# **OXFORDSHIRE COUNTY COUNCIL'S RESPONSE TO CONSULTATION ON THE FOLLOWING DEVELOPMENT PROPOSAL**

**Application no:** 14/02121/OUT-3

**Location:** Proposed Himley Village North West Bicester Middleton Stoney Road Bicester Oxfordshire

### **1) OCC response to Himley Village submission of 21 December 2016**

75 Cowcross Street London EC1M 6EL  
tel 020 7250 1555  
email aba@alanbaxter.co.uk  
www.alanbaxter.co.uk

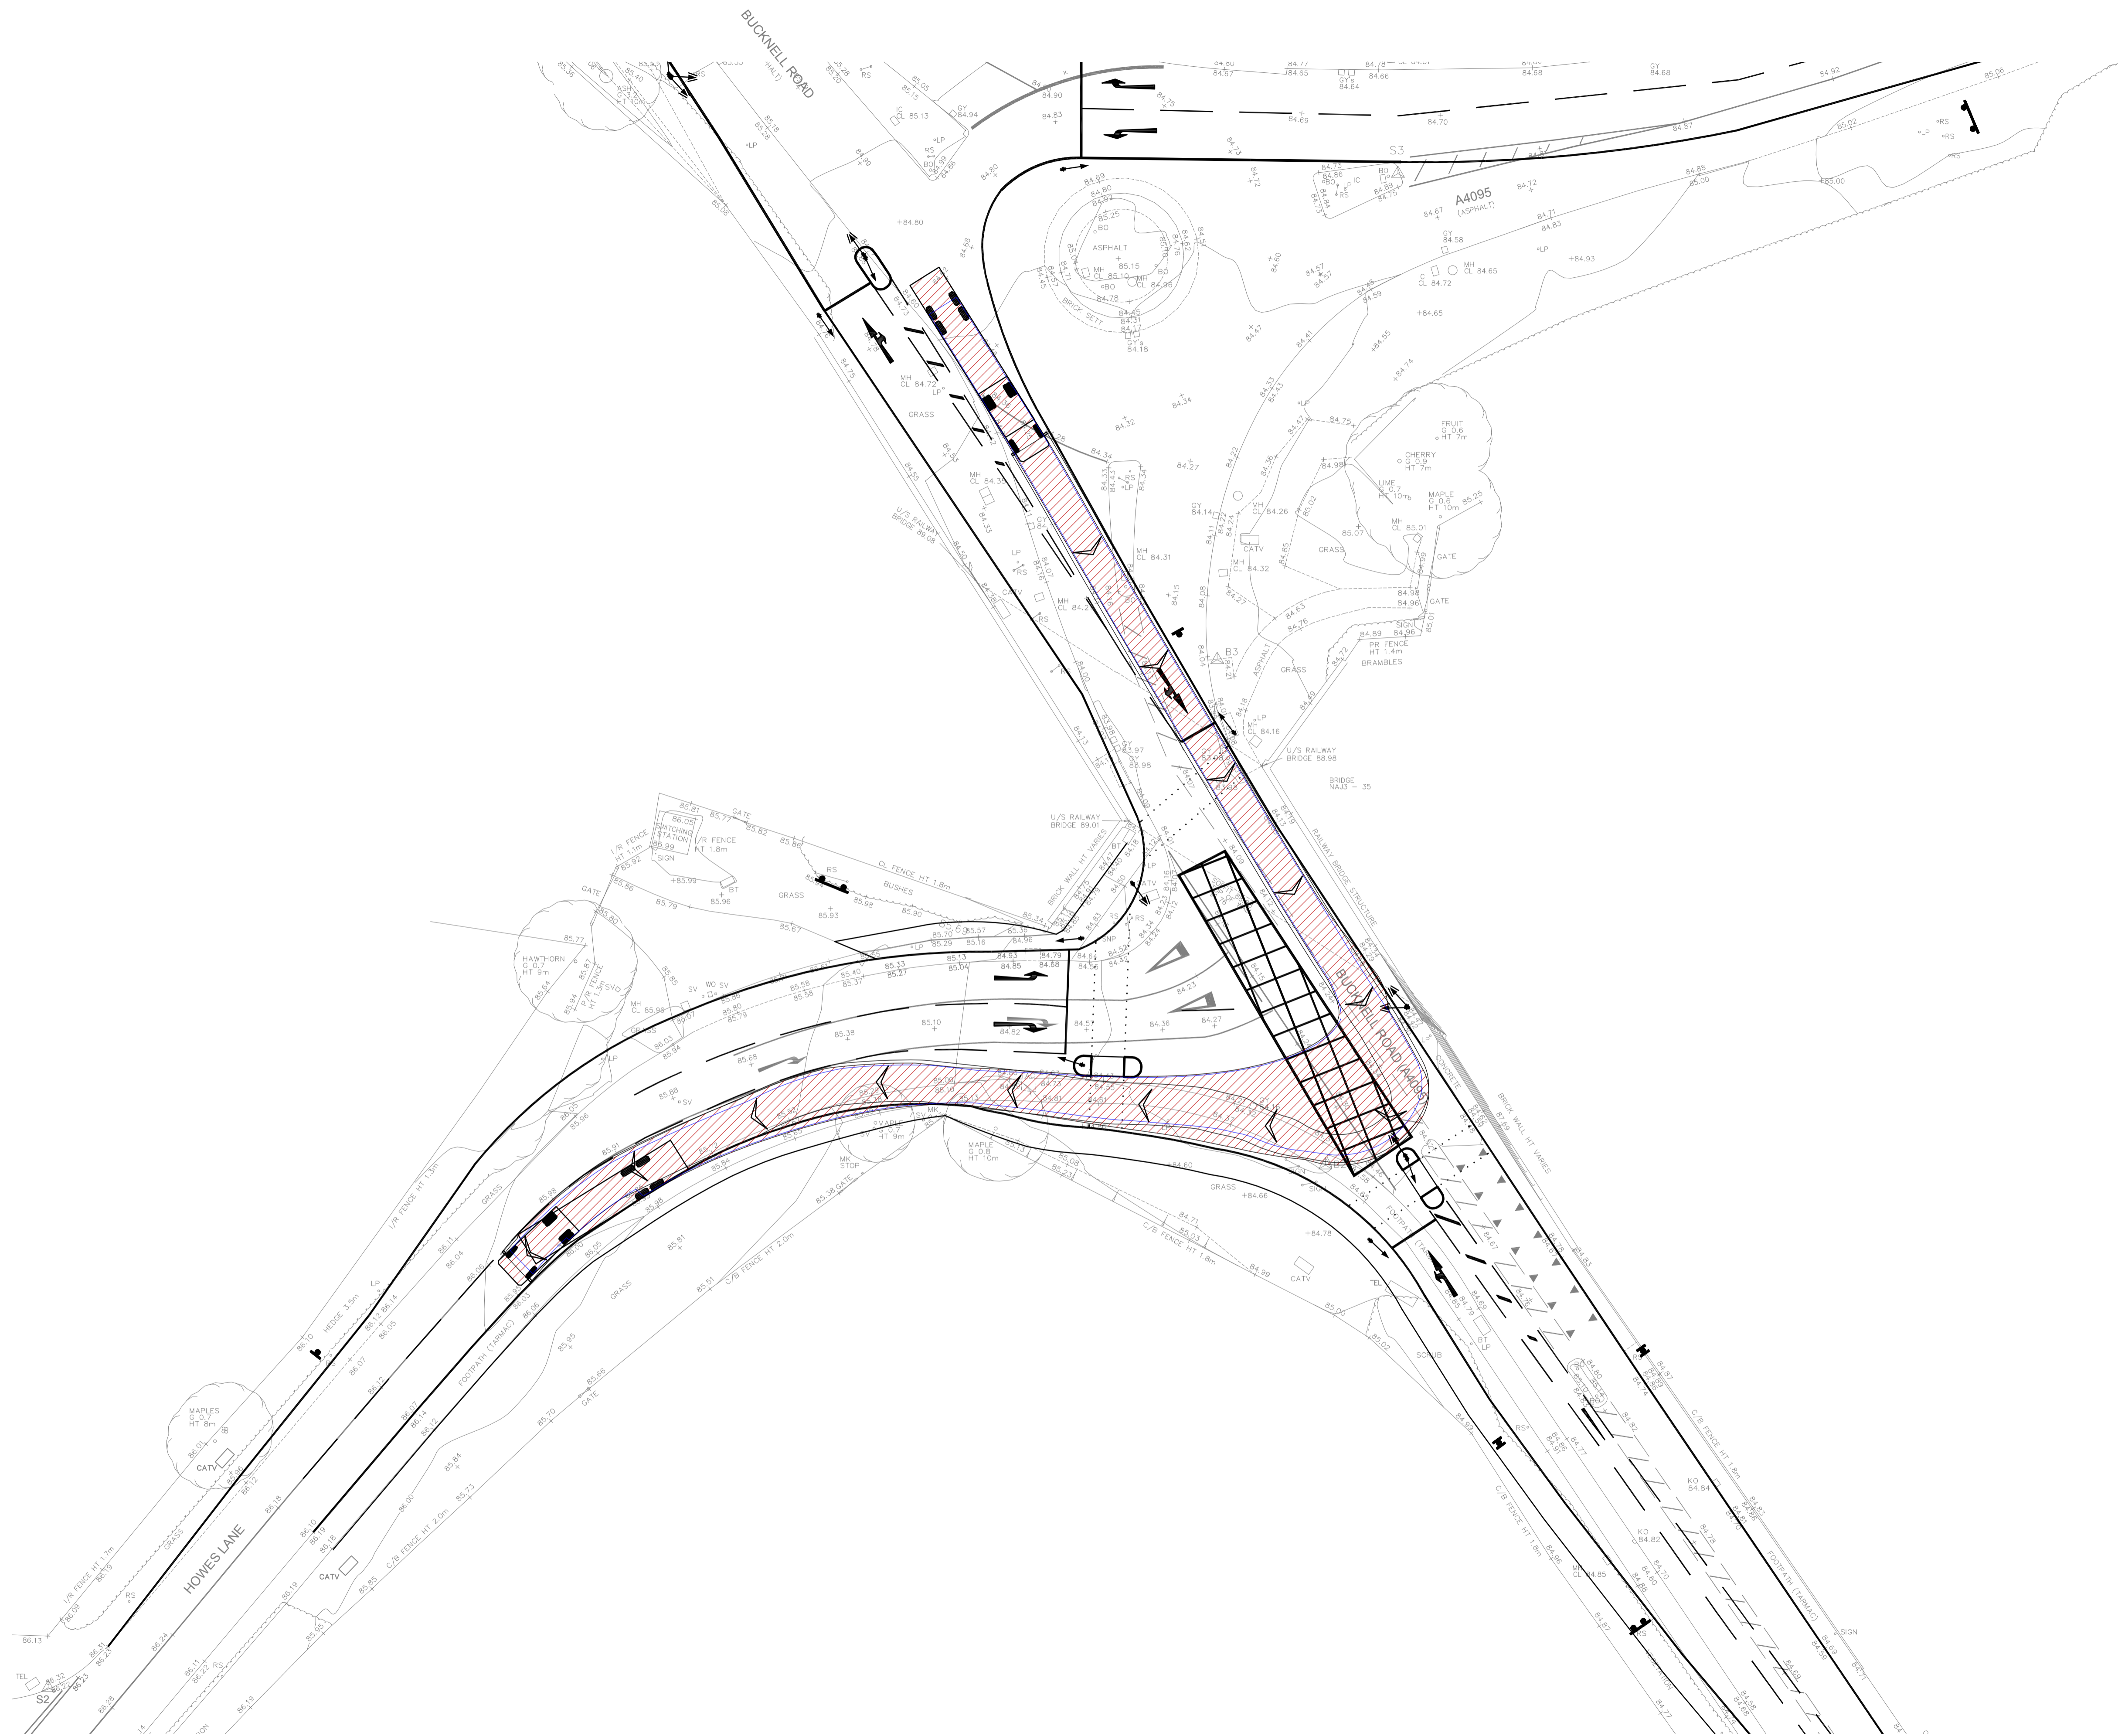
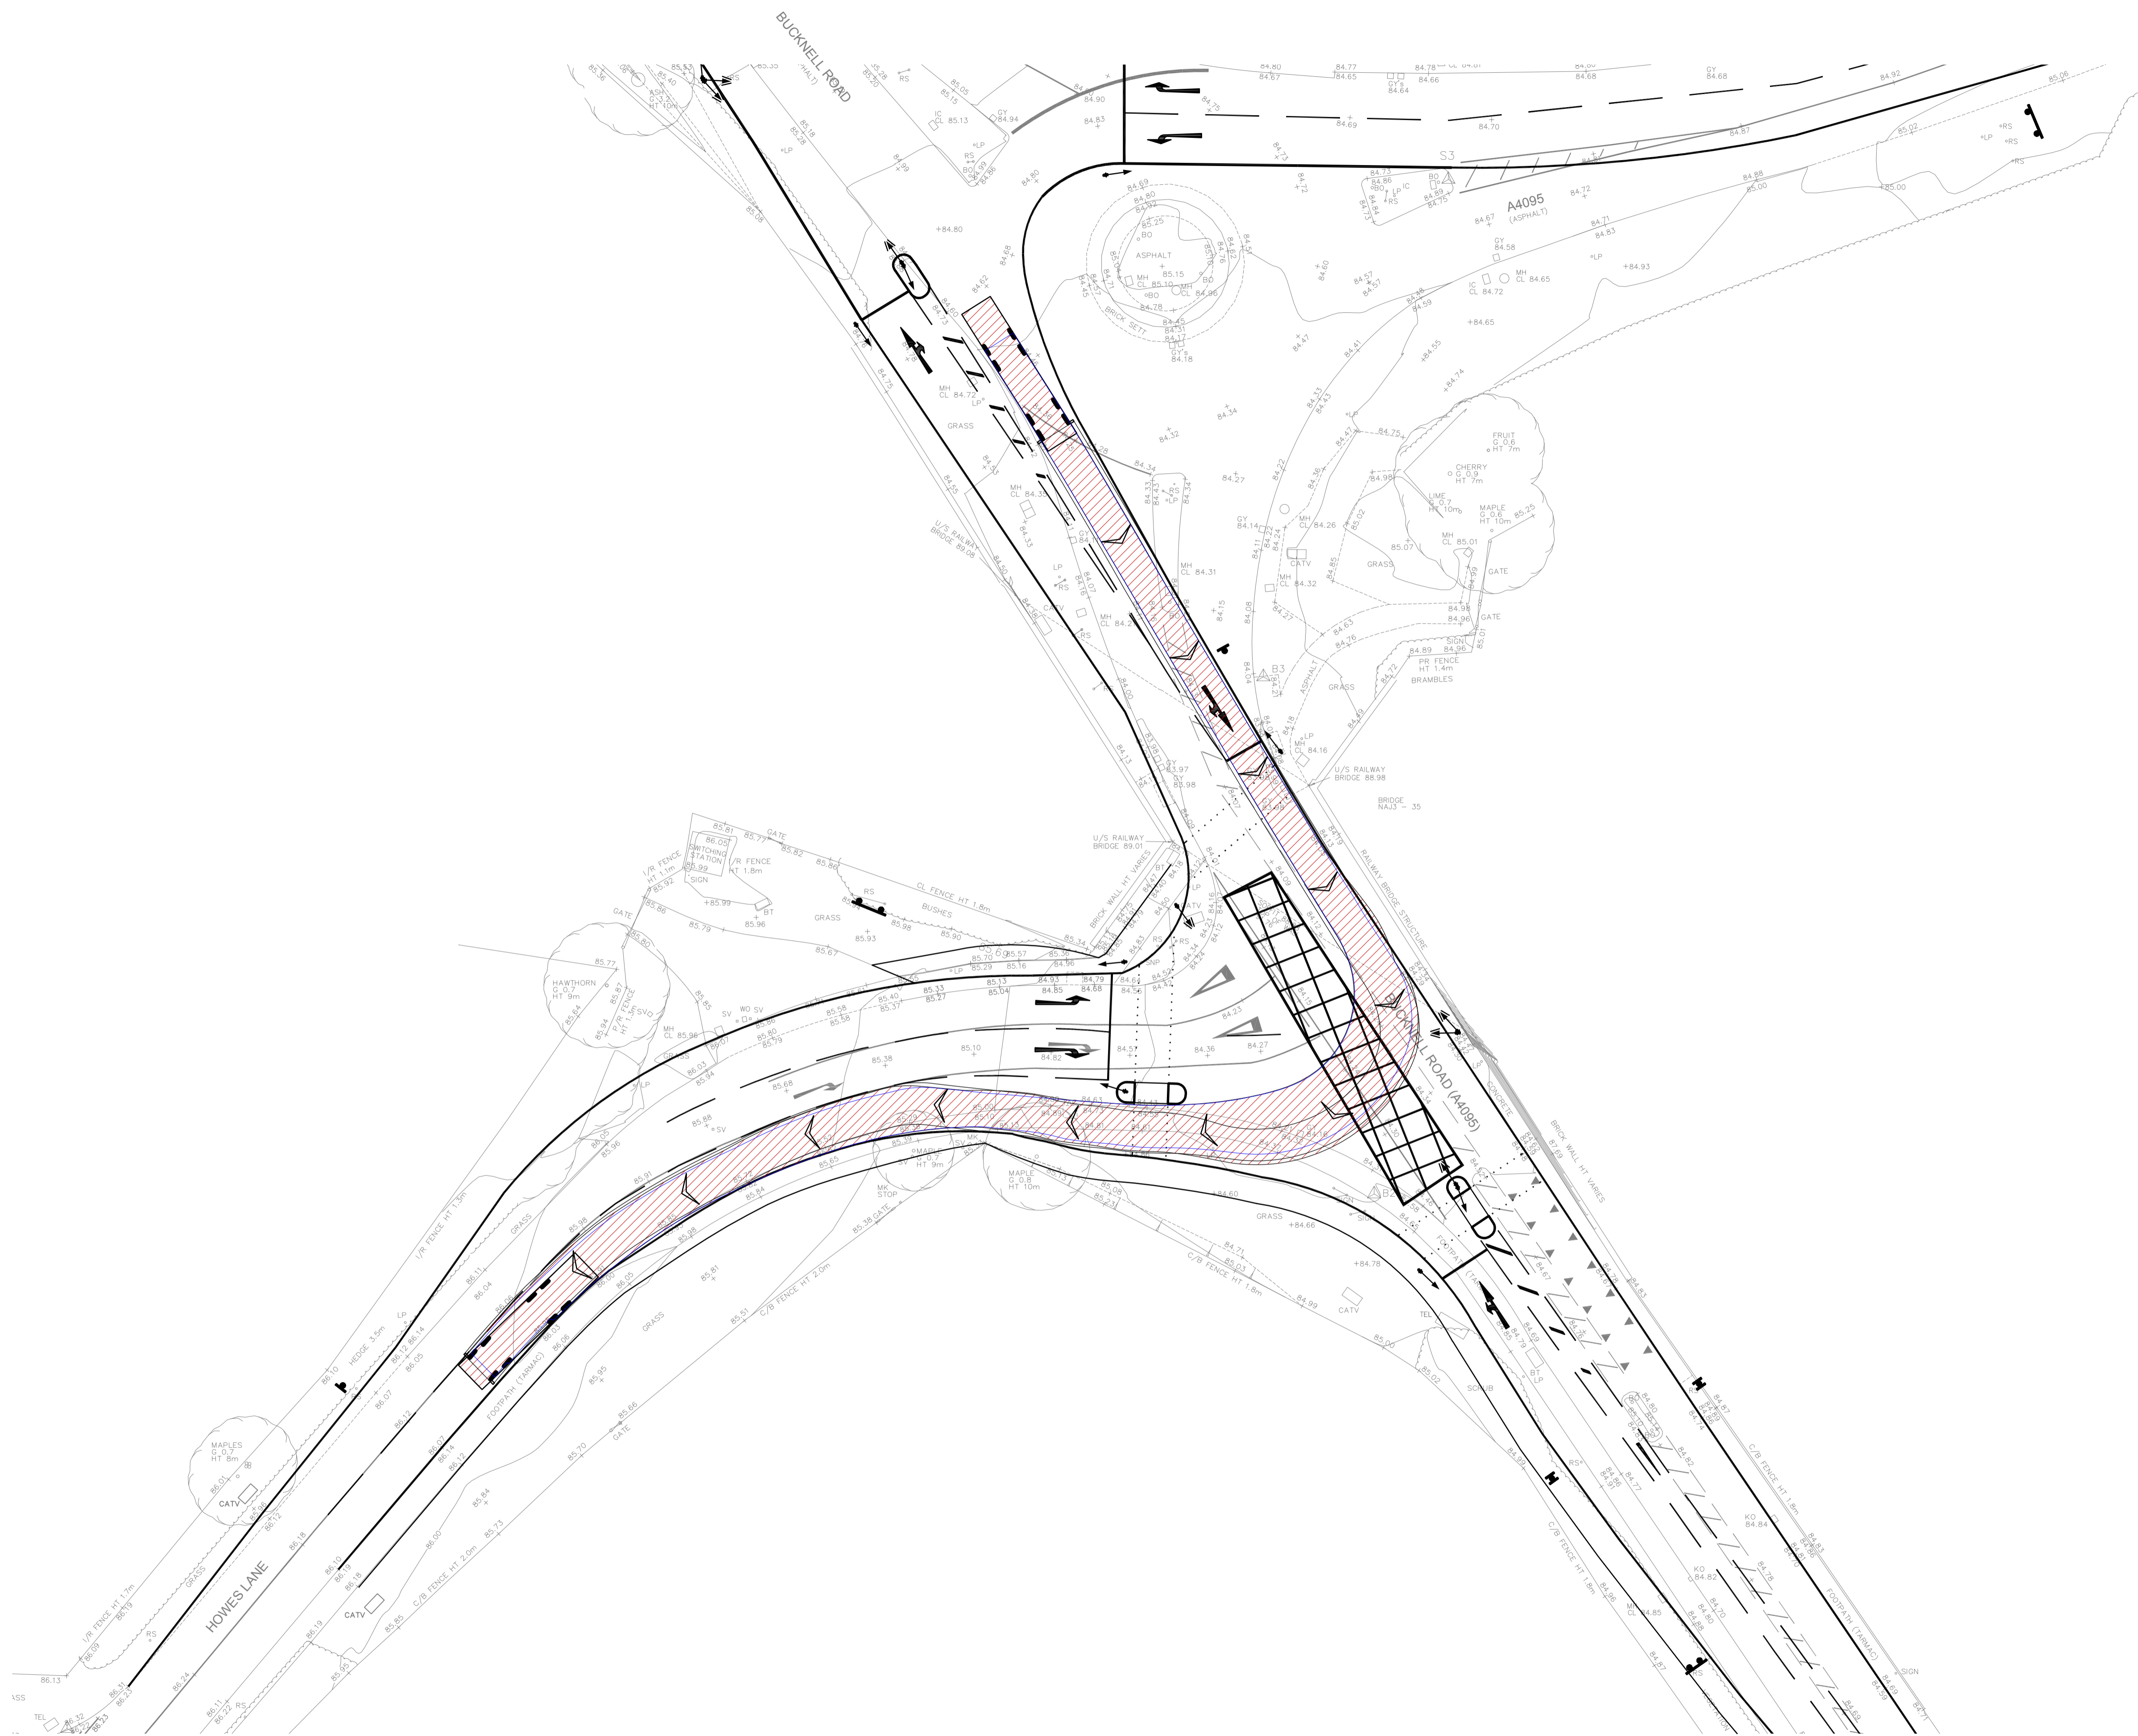
OCC maintains its objection to the proposed interim scheme because the submission does not demonstrate that previously identified problems can be remedied. Rather it states that these issues can be addressed at S278 application stage. The professional opinion of OCC engineers is that space at the junction is so constrained that it will not be possible to address the concerns and produce a design that will satisfy technical and safety audit, and that, as a result the scheme is not feasible. A full critique of the issues raised in the Technical Note is set out in Table 1 below.

Concern raised in OCC response of 15 Dec	Alan Baxter/PCL response to our concern	OCC response
Pinch Point on Howes Lane	<ul style="list-style-type: none"> <li>• Very low usage by pedestrians and cyclists during the hour surveyed therefore can assume low usage throughout the day and therefore very low risk of conflict.</li> <li>• Cyclist use of the footway is illegal anyway and the proposed scheme means they would be less likely to use the footway</li> <li>• Footway widths of no less than 1m at pinchpoints can be confirmed at next iteration of design (S278 application)</li> </ul>	<p>PCL, as part of the safety audit of the existing conditions carried out for Alan Baxter, did a ped/cycle count between 0740 and 0840 on Thurs 15 Dec. 2 peds and 3 cyclists were observed using the footway on the SE corner of the Bucknell Rd/Howes Lane jct.</p> <p>I would argue that this hour is not representative as it would not cover all people walking to work at the employment site and it is also unlikely to be representative of leisure users of the bridleway.</p> <p>In any case, I reiterate that even if pedestrian use is low, this does not remove the risk, either of collisions between peds or peds and cycles, or of peds/cycles being swiped by passing vehicle overhangs.</p>

<ul style="list-style-type: none"> <li>• Vulnerability of pedestrians given proximity to turning HGVs is noted but risk is discounted due to low number of pedestrians. PCL recommends widening footway to overcome this.</li> <li>• Suggestion that adherence to Inclusive Mobility guidelines is not required because people with mobility issues are unlikely to be using the footway here: 'people with mobility issues tend to undertake short journeys with a specific destination'</li> <li>• Footway extension on north side of Howes Lane could remove the problem provided sufficient widths can be maintained around street furniture. Recommendation to extend footway to Police Training Centre</li> <li>• Proposal of an option to look at relocating the central refuge on Howes Lane to provide additional footway width, and to carry out ped/cycle surveys during peak hours and weekends, for 'further development and finalisation of the junction design'</li> </ul>	<p>I also reiterate that, given the knowledge that cyclists use the footway, this must be taken into account. It cannot be concluded that cyclists would be less likely to use the footway in the proposed scheme. The Alan Baxter note says that 'experienced and confident cyclists (who are more likely to be on the carriageway than the footway) will position themselves so that they are close to the middle of the lane with vehicles following behind them' making it '...relatively easy for them to move across to the right hand lane on approach to the signals.' This reinforces my point, because the <u>less</u> confident cyclists are still likely to use the footway, as well as ones trying to avoid the queues. The provision of advanced stop lines would have little benefit as there is insufficient space to provide a lane leading into them, so cyclists would not be able to get to the front of the queue to enter the ASL box.</p> <p>I strongly refute the suggestion that people with mobility issues should not necessarily be catered for in this scheme, for reasons of inclusivity. In any case there is no basis for the suggestion that this kind of user would not wish to use this route.</p> <p>OCC engineers' professional opinion is that space at the junction is so constrained, that sufficient footway widths could not be found at the next iteration of the design, and that the scheme would not be deliverable as it would not pass its technical/safety audit.</p> <p>The footway on the northern side of Howes Lane would be welcomed if there is sufficient space. However, the applicant has not demonstrated that this is feasible. Even though it would make the footway on the south side largely redundant, the</p>

<p>distance from the kerb to the garden fence on the south side could not be reduced further, as sufficient verge is required for maintenance.</p>
<p>Crossing point on Bucknell Rd between Howes Lane and Lords Lane</p>	<ul style="list-style-type: none"> <li>• Proposals provide better visibility between pedestrians waiting to cross and vehicles turning left out of Howes Lane, as well as better awareness of pedestrians under signalisation, in the proposed scheme compared with the current situation.</li> <li>• Signalisation improves the opportunities for crossing safely here, even without a pedestrian phase, and also increases the predictability of vehicle movements, allowing regular users to learn when in the traffic signal phasing, it is safe to cross.</li> <li>• Proposal of an option to consider a pedestrian phase on the assumption that it would not be called every cycle (and therefore may not impact on capacity).</li> </ul>	<p>CPL has carried out a Stage 3 safety audit for Alan Baxter, of the existing arrangements. Please see discussion of that safety audit below as we do not accept its findings and it does not agree with the independent safety audit carried out for the recent mitigation scheme at the junction.</p> <p>The predictability argument is not conclusive, but even if I was prepared to concede this point, we still have significant concerns about this crossing point. The crossing point is at a pinch point where the tactiles would be only 0.7m wide (between the kerb and the bridge abutment wall) at their northern point, and vehicle tracking is extremely close to the kerb.</p> <p>Also, on rechecking the drawings, the intervisibility zone is well below DMRB standard (and here I have to correct my previous comment that the intervisibility was adequate) due to the major obstruction of the bridge wall. Whilst there is intervisibility between the stop line on Howes Lane and the crossing point, DMRB requires intervisibility between points 2.5m back from the stop line extended across the carriageway, which the proposed scheme does not provide for, so it does not meet standards.</p> <p>There is a risk that the change to the kerblines could make it easier for vehicles to take the left turn faster than at present. On a green signal, drivers will not hesitate in order to give way to traffic from the right, and may in fact accelerate up to the traffic signals and take the corner quickly, in order not to miss the</p>

<p>green signal, putting pedestrians at risk. Having less than standard intervisibility due to the bridge wall may well exacerbate this risk.</p> <p>Intervisibility between points behind the stop line is primarily required to cater for instances when traffic signals fail and drivers need to see when it is safe to proceed. The fact that the scheme does not meet the standard could well be a reason that a S278 agreement cannot be reached.</p> <p>In terms of pedestrian safety, pedestrian phases would be welcomed, but would have the potential to reduce the capacity of the junction and would need to be modelled. The assumptions regarding frequency of call only once every 7.5 cycles would need to be tested against surveys with pedestrian demand growthed up in line with traffic growth. This would then need to be demonstrated through updating the LinSig model.</p>
Signal equipment and traffic signs		<p>We are agreed that there are likely to be ways of accommodating signage and traffic signals so as not to create an obstruction on the footways but this would need to be demonstrated.</p>

Vehicle tracking	<ul style="list-style-type: none"> <li>Proposals are an improvement on current situation.</li> <li>There is scope to refine the design 'to accommodate instances where swept paths show vehicles crossing the centre line and coming close to the kerb line'</li> <li>Combination of low ped and HGV use means low risk of</li> </ul>	<p>CPL has carried out a Stage 3 safety audit for Alan Baxter, of the existing arrangements. Please see discussion of that safety audit below as we do not accept its findings and it does not agree with the independent safety audit carried out for the recent mitigation scheme at the junction.</p> <p>OCC engineers' professional opinion is that space at the junction is so constrained, that there is no scope to widen the carriageway to address tracking issues, without reducing the footways unacceptably.</p>

<p>conflict in comparison to existing situation.</p> <ul style="list-style-type: none"> <li>• Design of central refuge is in accordance with current guidance.</li> <li>• Swept path in any case provides a margin of safety.</li> <li>• Containment kerbs may be used to prevent damage to structures.</li> </ul>	<p>I do not understand the statement that the swept path provides a margin of safety. It is based on the actual vehicle widths of the design vehicles including their wing mirrors. The notes on the swept path drawings state:  <i>'The computer programme assumes an 'optimum vehicle' in terms of performance and driver ability and hence additional areas for unrestricted movement may be required.'</i></p> <p>Whilst it is acknowledged that the refuges would be of benefit to pedestrians, they result in very tight tracking which would only be achieved by an 'optimum vehicle', implying that in practice the situation could be worse than shown in the drawings.</p> <p>HGV use of the junction will inevitably increase as a result of construction and development around Bicester. Pedestrian use of the junction will increase in proportion with general traffic growth. This means the frequency of potential conflict will increase.</p> <p>It is acknowledged that the refuges are 1.5m wide and therefore in accordance with current guidance in this respect.</p> <p>The use of containment kerbs as satisfactory to prevent damage to the bridge structure, given that the kerb would move to only 700m from the structure, has not been discussed with Network Rail and there is no certainty that this would be accepted by Network Rail at the approval stage.</p>
